Our Ref: 2500/SES/SES/SES/20120827

27 August 2012

Re: Response to Submissions - Surface Water and Groundwater Assessment – Lakes Estate Residential Subdivision Development, North Boambee Valley, Coffs Harbour

**Lakes Estate Catchment
Area Stormwater Constraints**

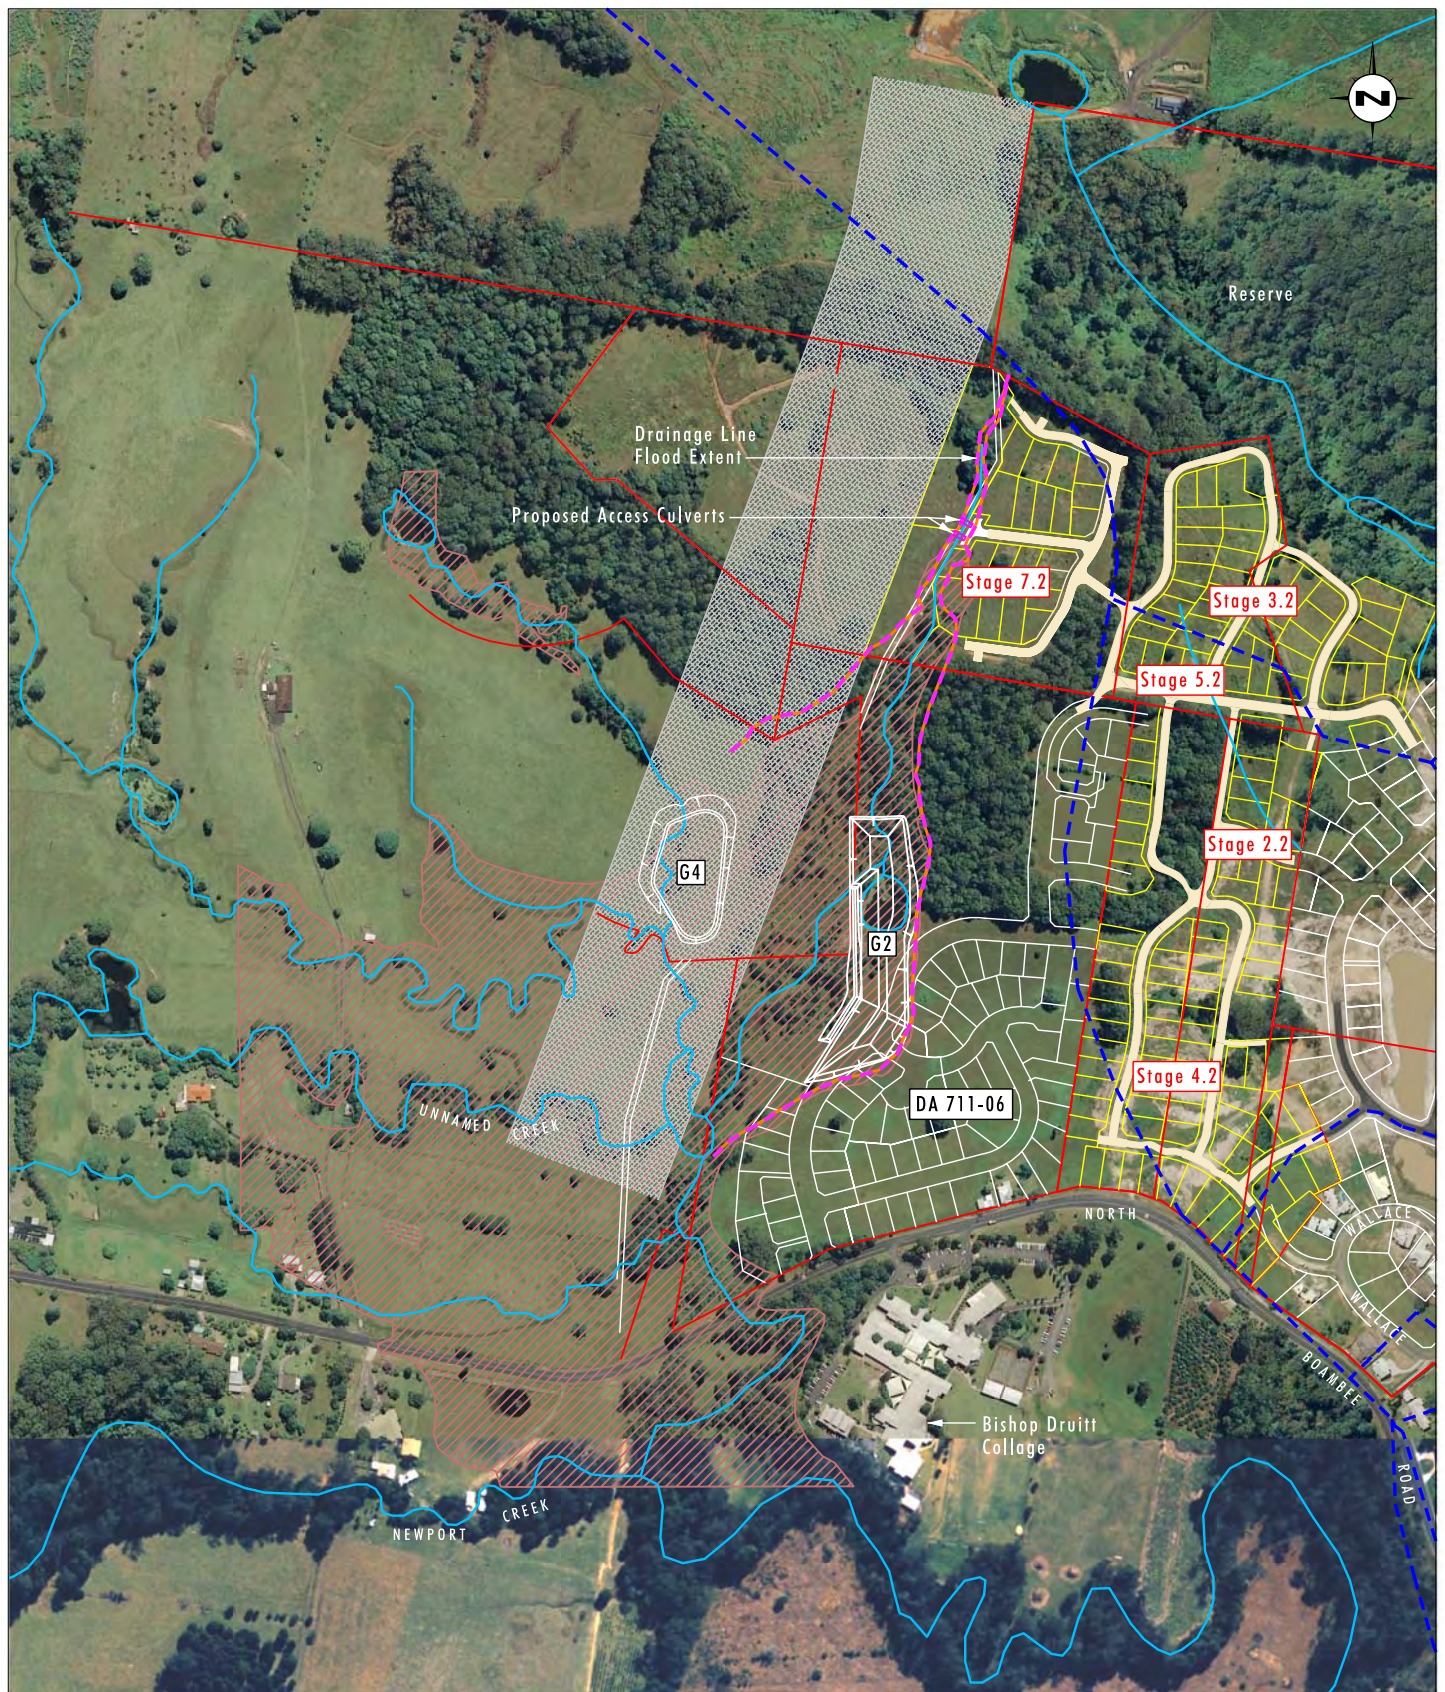
The intersection of North Boambee Rd and the Pacific Highway is subject to serious flooding during significant rainfall events. The additional 196 residential lots are expected to increase the amount of stormwater run-off directed to the south-east towards North Boambee Road. There are concerns that businesses located along North Boambee Road and on the intersection of the Pacific Highway will be detrimentally affected by the increased stormwater flows, particularly if the five lake system is at full capacity. This issue is required to be addressed.

It is noted that the proposal includes fill within the 100 year flood extent. The assessment did not consider the cumulative impacts of similar developments across the complete Newports and Boambee Creek catchments. It has been found that such fill has had an adverse impact on the flood behaviour in the adjacent Coffs Creek. It is recommended that the planning controls adopted for Coffs Creek be adopted for this catchment viz, no net filling within the 100 year flood extent except where compensatory cut/fill within the flood storage is permitted.

As outlined in Section 2.0 of the Surface Water and Groundwater Assessment (Umwelt 2008) the previously approved stormwater detention system has been designed to incorporate residential development within the proposed subdivision. The original, Council approved stormwater detention system (GHD 1997) and the five lake system (Umwelt, 2003) was designed to reduce the subdivision's post-development peak flows to less than or equal to that of the pre-development peak flows.

The assessment indicates that the potential impacts associated with the proposed fill are offset by the detention provided for within the stormwater management system (refer to Table 5.1 of the Surface Water and Groundwater Assessment). As such compensatory cut/fill has already been provided for within the design and construction of the existing stormwater management system for the Lakes Estate.

**Western Catchment Area
Stormwater Constraints**

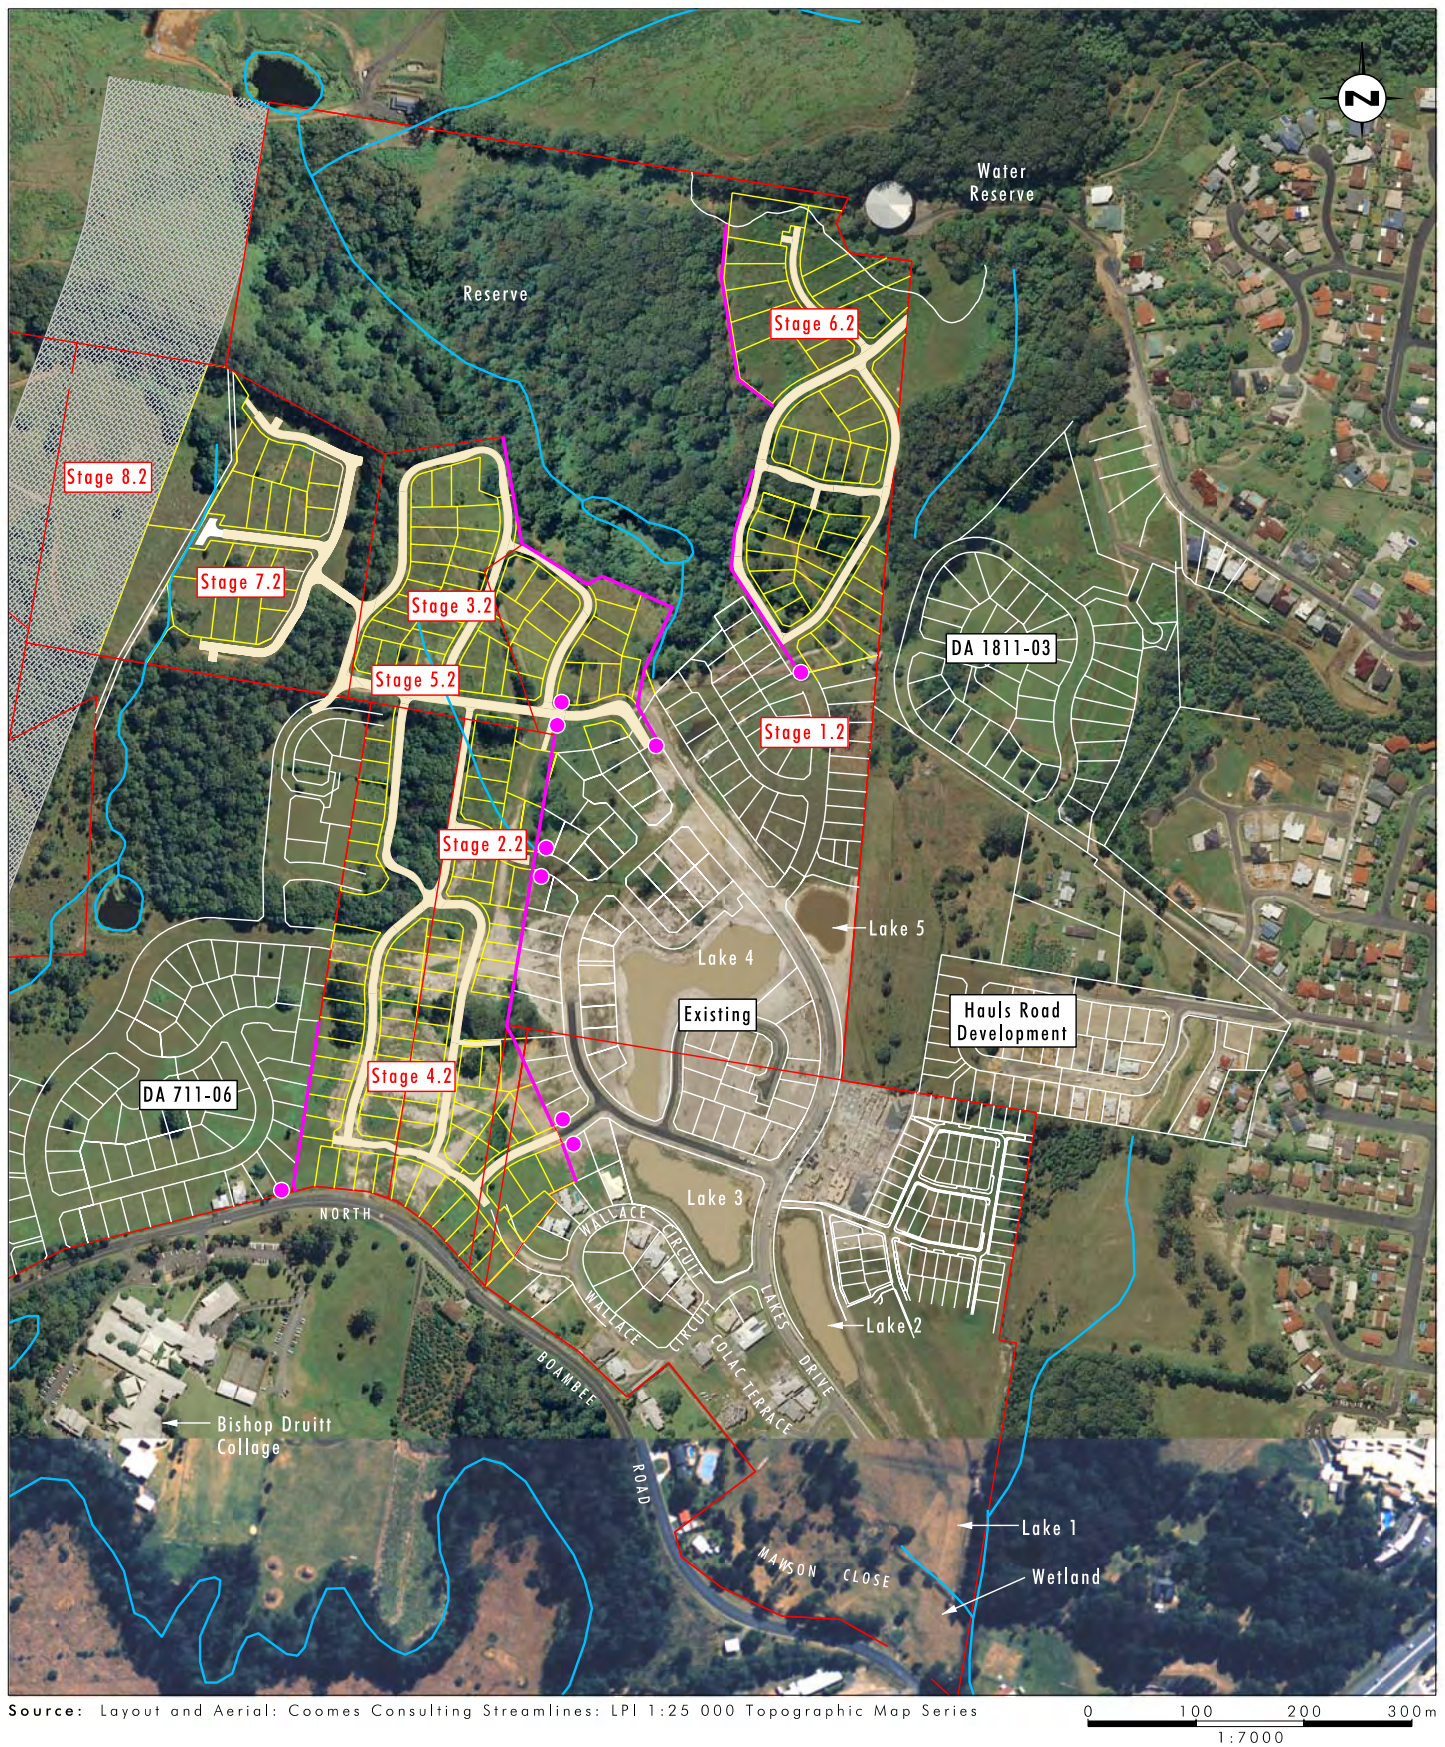
The Director-General's EA requirements included the consideration of the likely effects of fill on the flood regime of the site and adjacent lands. Stage 2 includes some low lying land to be filled. The application does not appear to have addressed this in Section 6.5.5 or the Stormwater Management Plan.

Proposed Lots 87 to 106 are affected by flooding. From the Flood Study the 1 in 100 year flood level is estimated at 9.9 metres AHD for the majority of the area and rises to approximately 12.2 metres AHD around Lot 104.

The small catchment that flows from the north is estimated to have a 1 in 100 year flow of 5.5 m³/s. The 9.9 metre AHD would be backwater from the watercourse downstream. This part of the subdivision needs to be reviewed in relation to flooding.

The potential impacts of fill works are addressed in Section 6.3 of the Surface Water and Groundwater Assessment (Umwelt 2008). The modelling indicates that channelisation of these flows and associated filling will not increase flood levels downstream of the proposed development areas.

In addition, the proposed modifications to the development plans remove the need for some of the filling works within the 100 year ARI flood extent. Potentially two lots within the western catchment area are located within the 100 year ARI flood extent, however the layout provides sufficient land for a building envelope to be located outside of the modelled flood extents.

As discussed in Section 3 of this letter, the potential impacts of fill works are addressed in Section 6.3 of the Surface Water and Groundwater Assessment (Umwelt 2008). The modelling indicates that channelisation of these flows and associated filling will not increase flood levels downstream of the proposed development areas.

In addition, the proposed modifications to the development plans remove the need for some of the filling works within the 100 year ARI flood extent. Potentially two lots within the western catchment area are located within the 100 year ARI flood extent, however the layout provides sufficient land for a building envelope to be located outside of the modelled flood extents.
